**Southern
Water**

Proposal: Outline planning application (with all matters reserved except for access) for the development of up to 1,500 dwellings (Use Class C3), 60-bed care home (Use Class C2), up to 9,000 sqm of employment floorspace (Use Classes B1), local centre of up to 2,350 sqm including up to 900 sqm retail / commercial (Use Classes A1-A5) and 1,450 sqm community / leisure floorspace (Use Classes D1-D2), land for a two-form entry primary school (Use Class D1), public open space, allotments, new sports pitches and associated facilities, drainage, parking and associated access, infrastructure, landscape, ancillary and site preparation works, including demolition of existing buildings and part removal of existing runway hardstanding. This application affects a Public Right of Way. This application is the subject of an Environmental Statement. This application falls within CIL Zone 1 - Zero Rated.

Site: F/4/20/OUT: - Land at Ford Airfield Ford, West Sussex BN18 0HY.

We write further to our letter dated 24/11/2021 and in response to the issuing of planning condition 35 for application F/4/20/OUT.

Crown copyright and database rights 2021  
Ordnance Survey 0100031673  
OS data licence expiration: 05.02.22

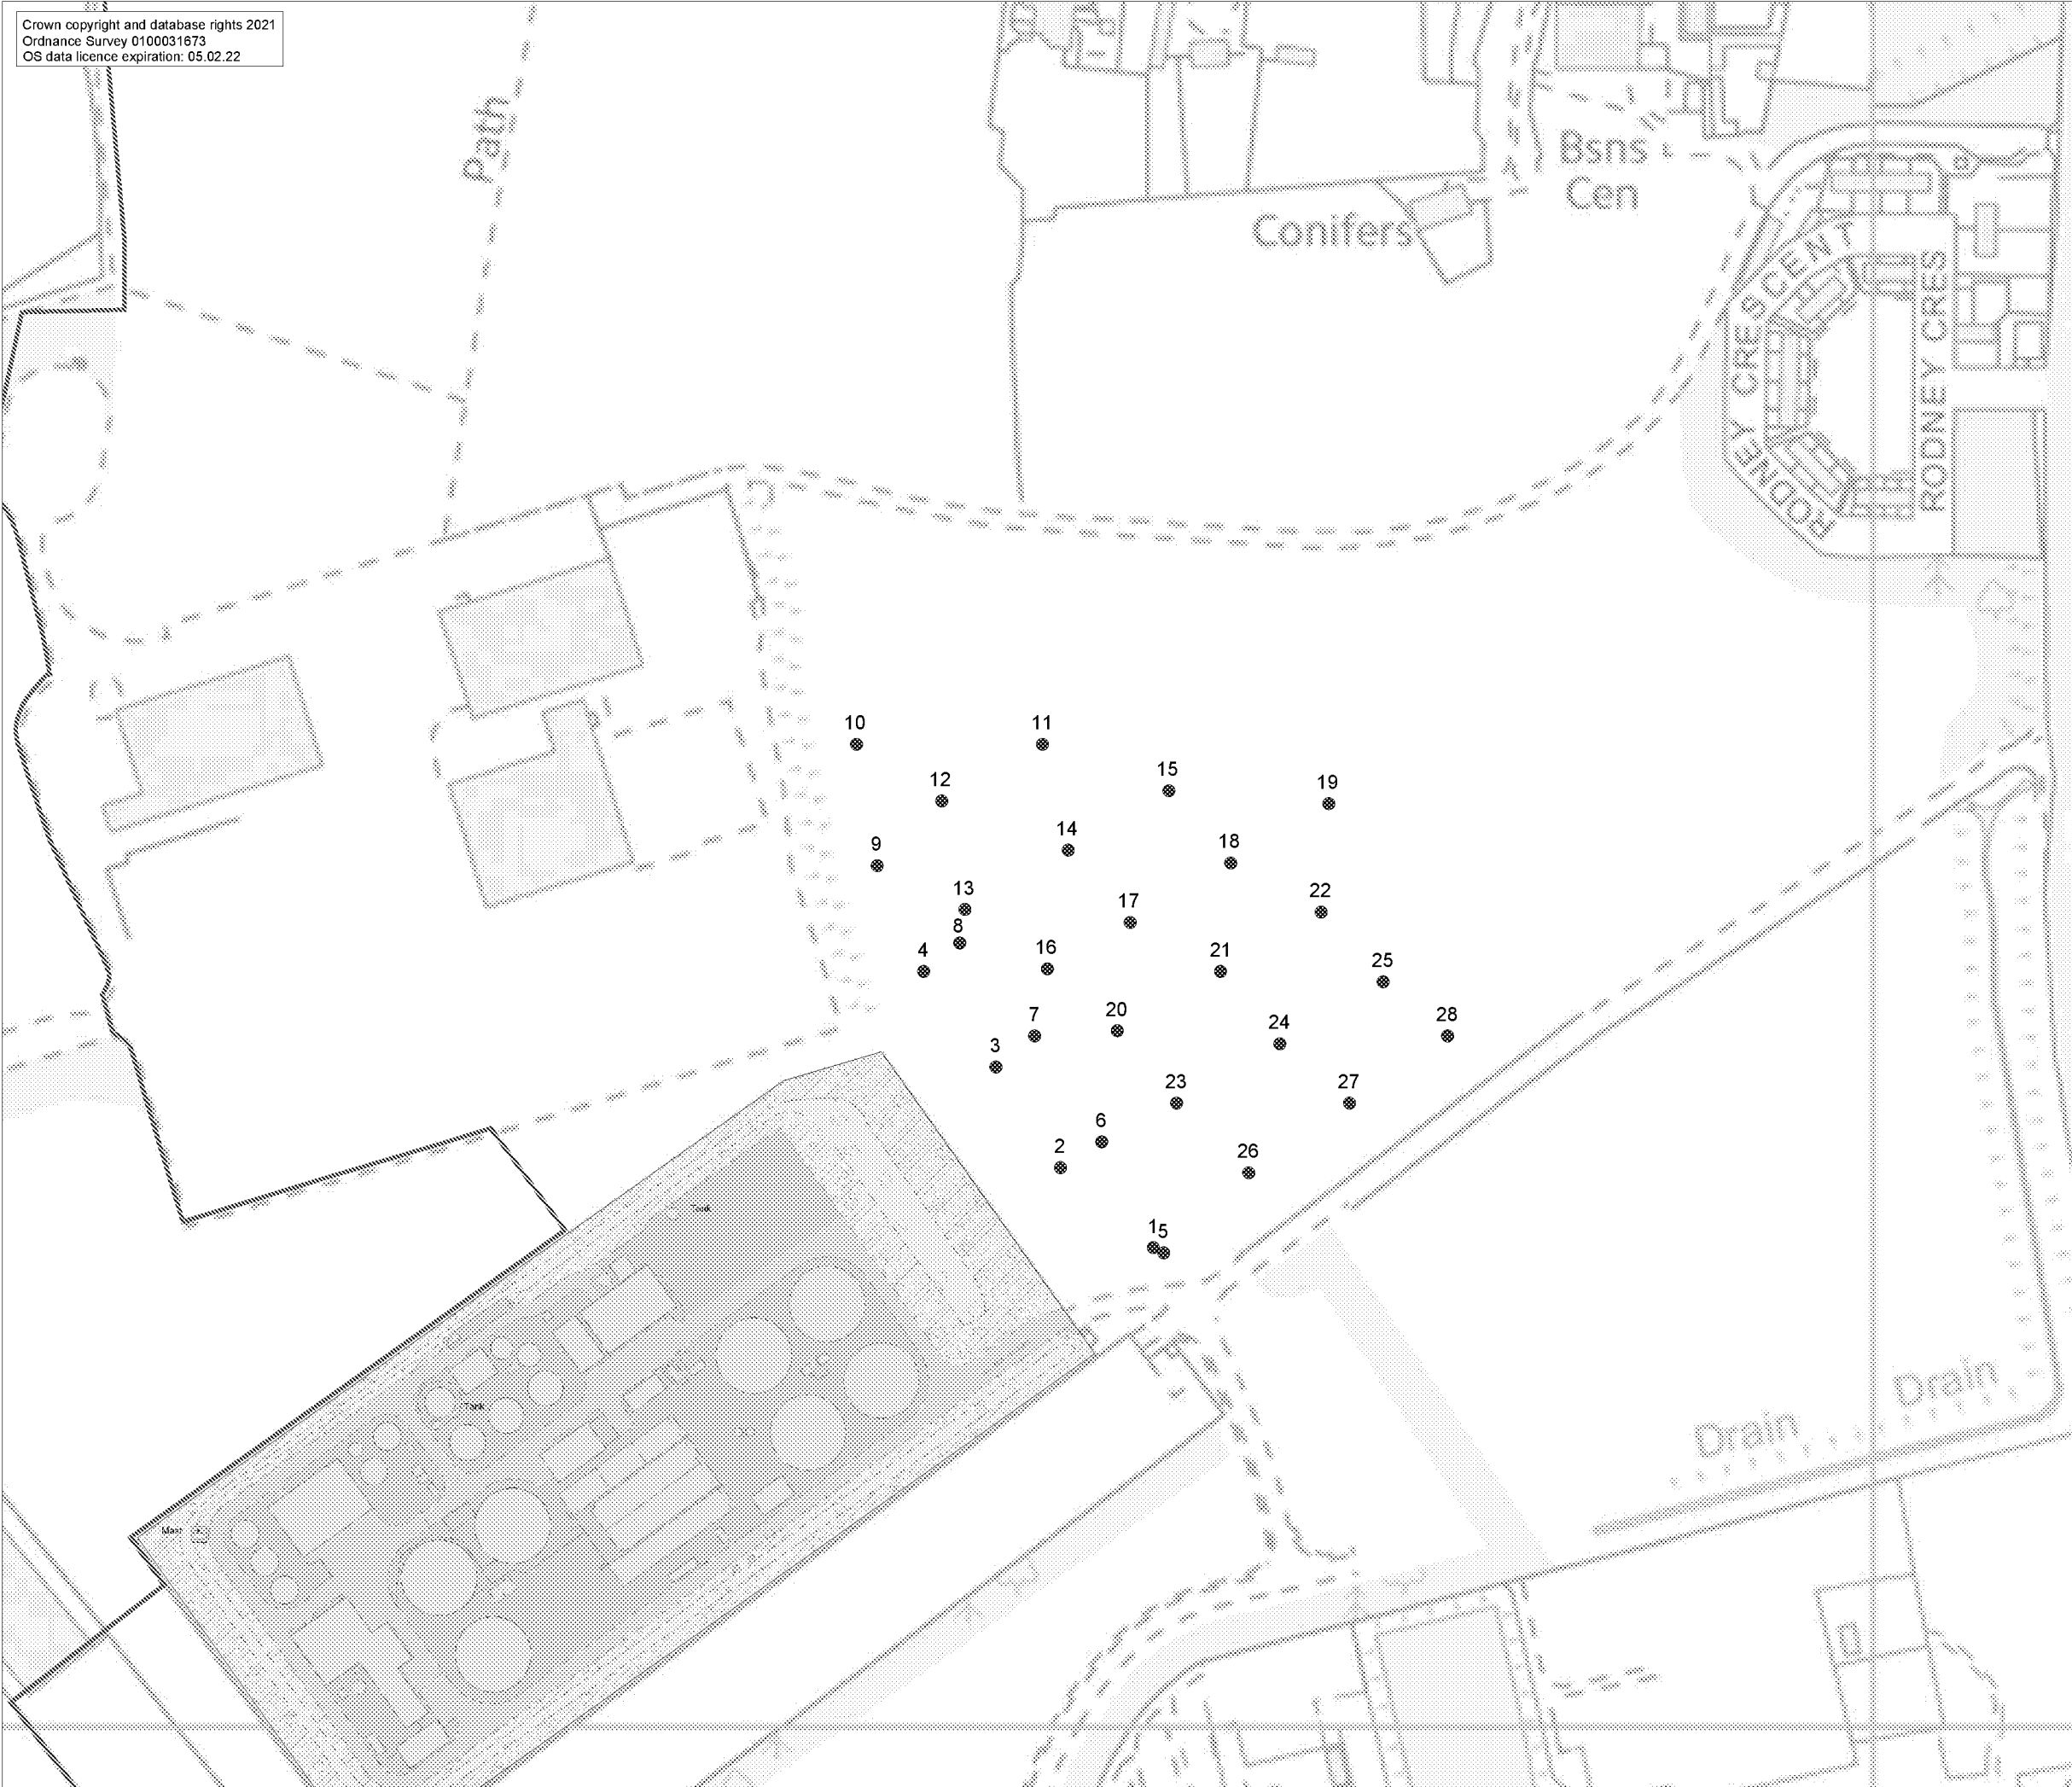
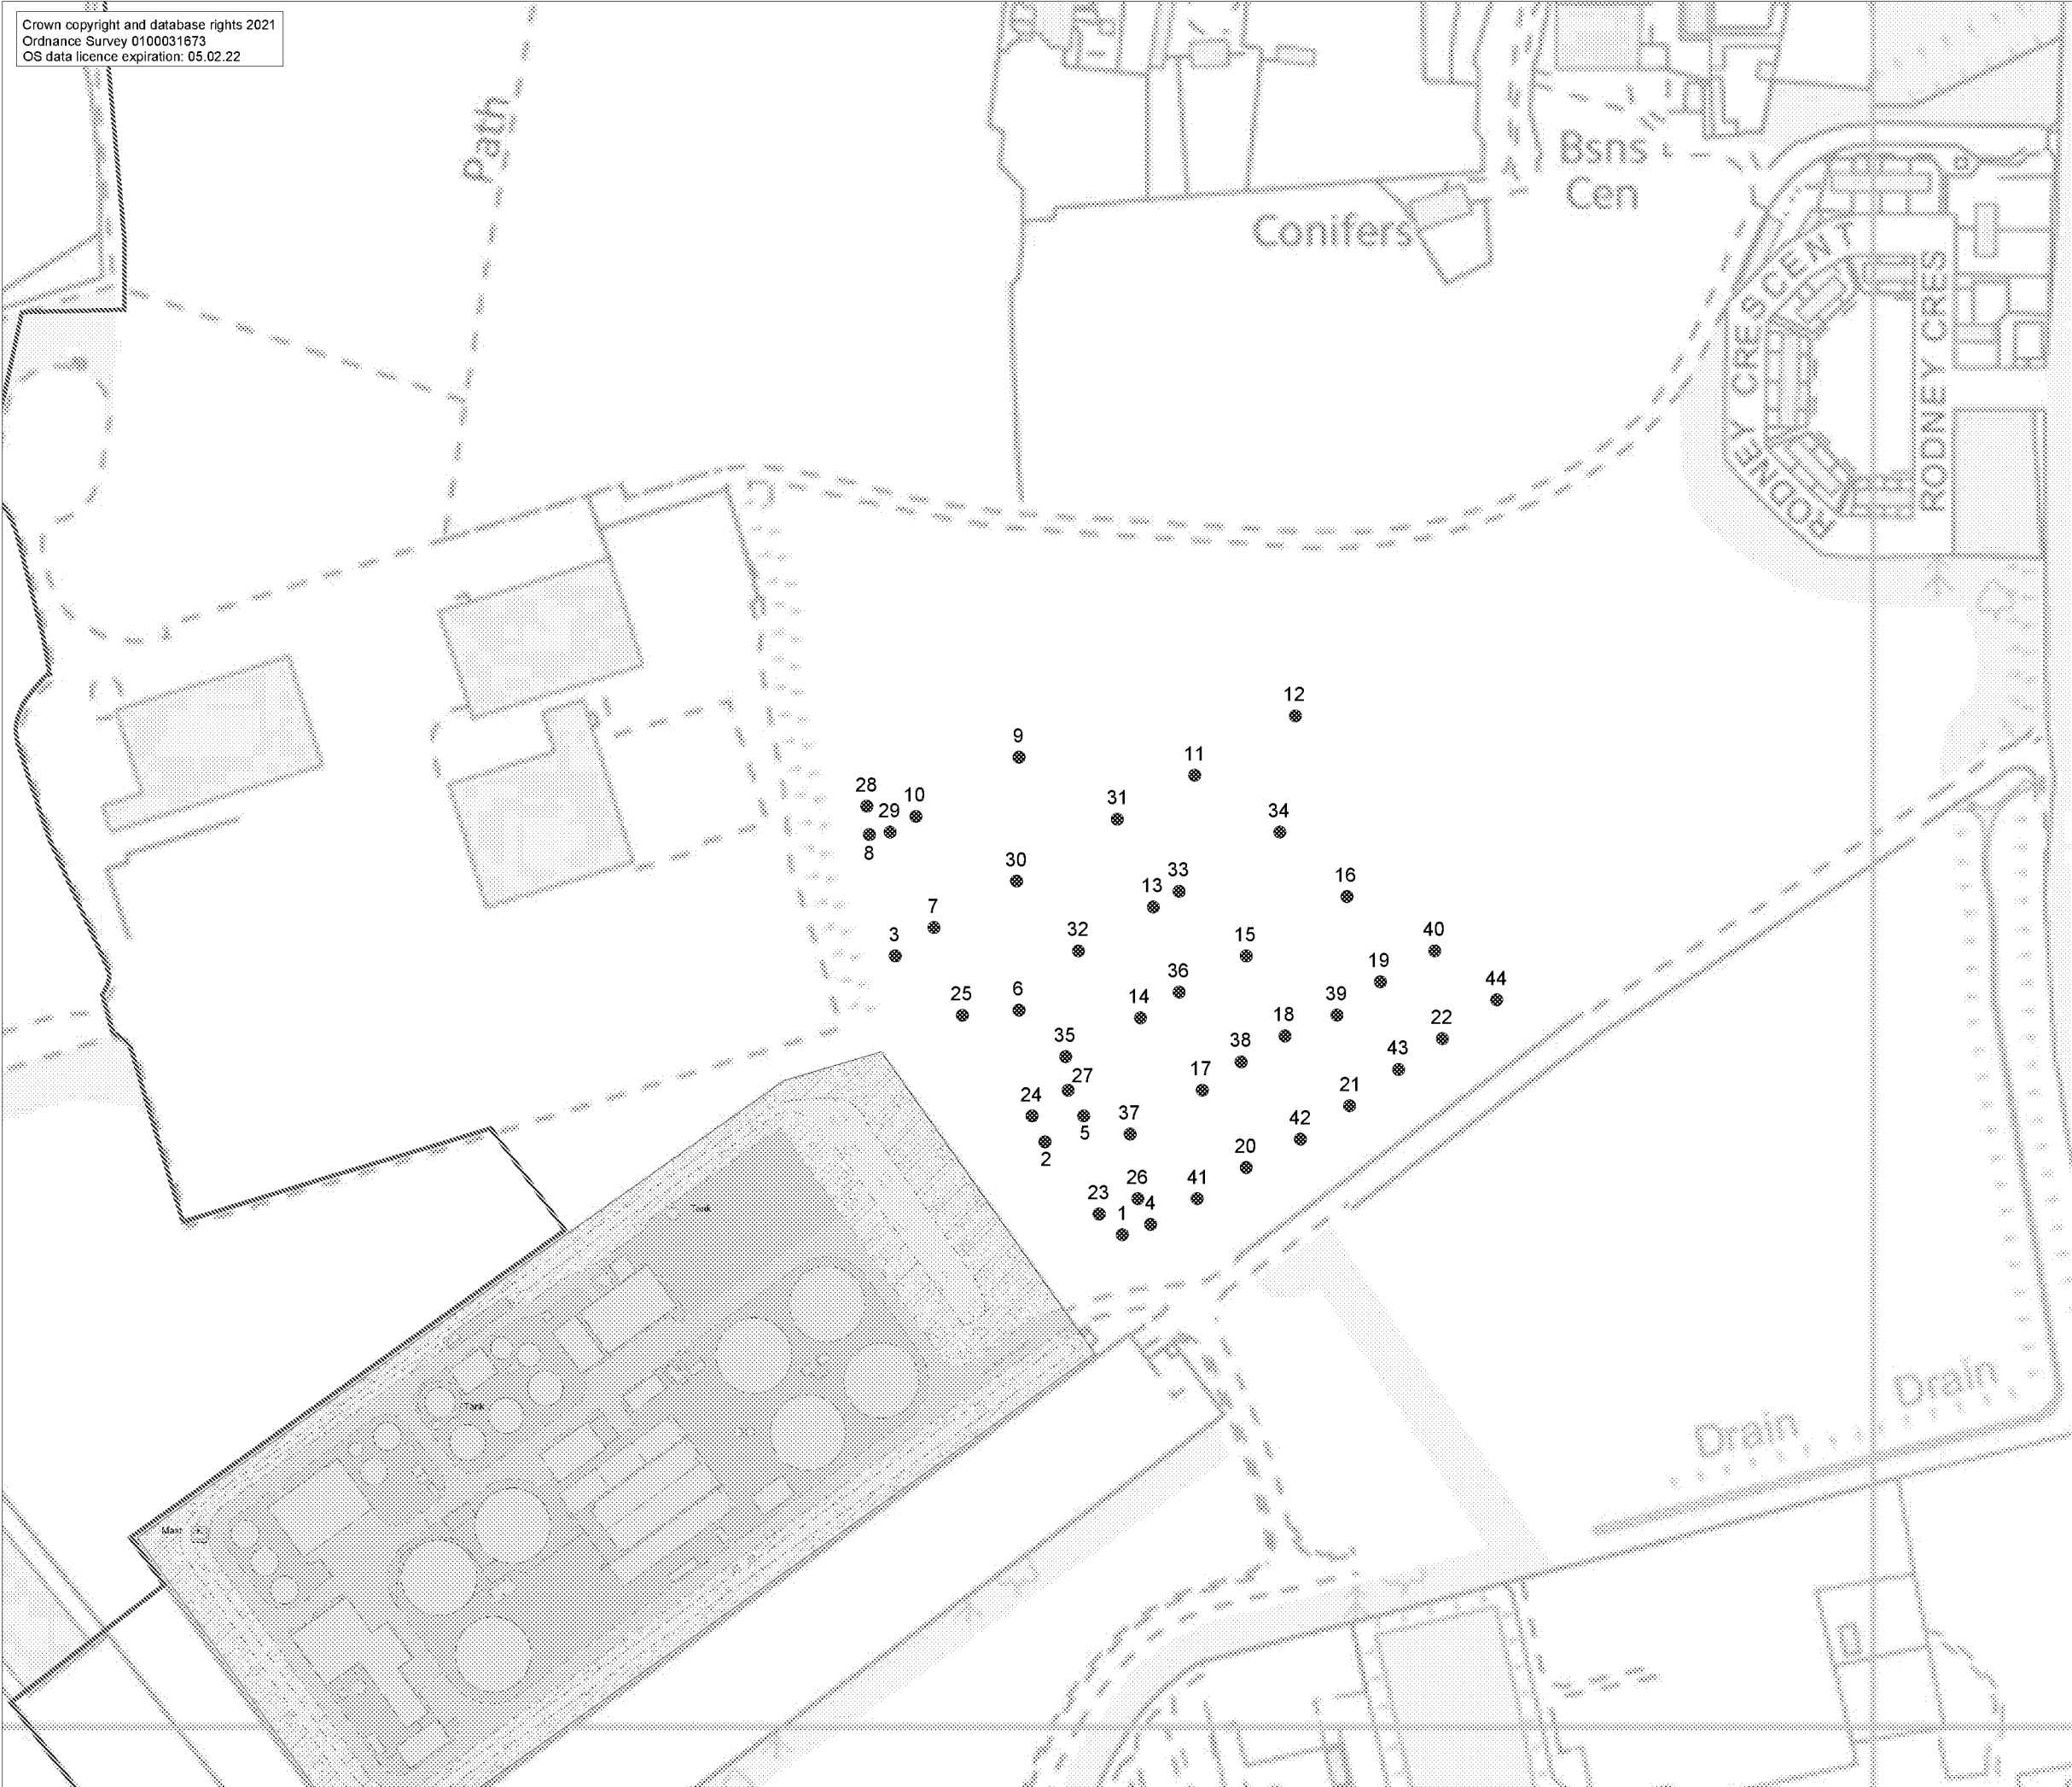
Condition 35 of the application, requesting a 300m buffer from the ASP, seems to be a misinterpretation of the advice provided by the Council's odour advisors.

The 300m buffer should be the area drawn from the ASP, Main OCU and Sludge OCU rather than just the ASP. The OCUs were identified as the 'most odorous part of the WwTW' and emissions from these areas, observed to be 'moderate' and significant, were detected at distances up to 300m in odour surveys.

Please can we receive a response advising as to why the buffer distances were applied only from the ASP and not the other 'main odour' sources identified by the assessment. Emissions from these sources were detected in excess of 300m from the source, noting the following quotes from the November 2021 Phlorum odour assessment review:

- "2.30 During walkover/sniff test 1, strong odours could be detected transiently but regularly up to 120m from the WwTW boundary, and at least 300m from the most odorous part of the WwTW, i.e., the main works odour control unit. The three locations where strong odours could be detected were not the three closest, as is suggested in the report, suggesting that a plume from the OCU might be grounding there".
- "2.4. Such discrepancy between modelled and observed results should point to the adoption of the precautionary principle. If unacceptable odour contours are predicted to occur 300m from sludge processes, then this ought to be considered the radius in all wind directions where such odours could affect the application site. This would be a more robust way to inform the appropriate layout of the masterplan."
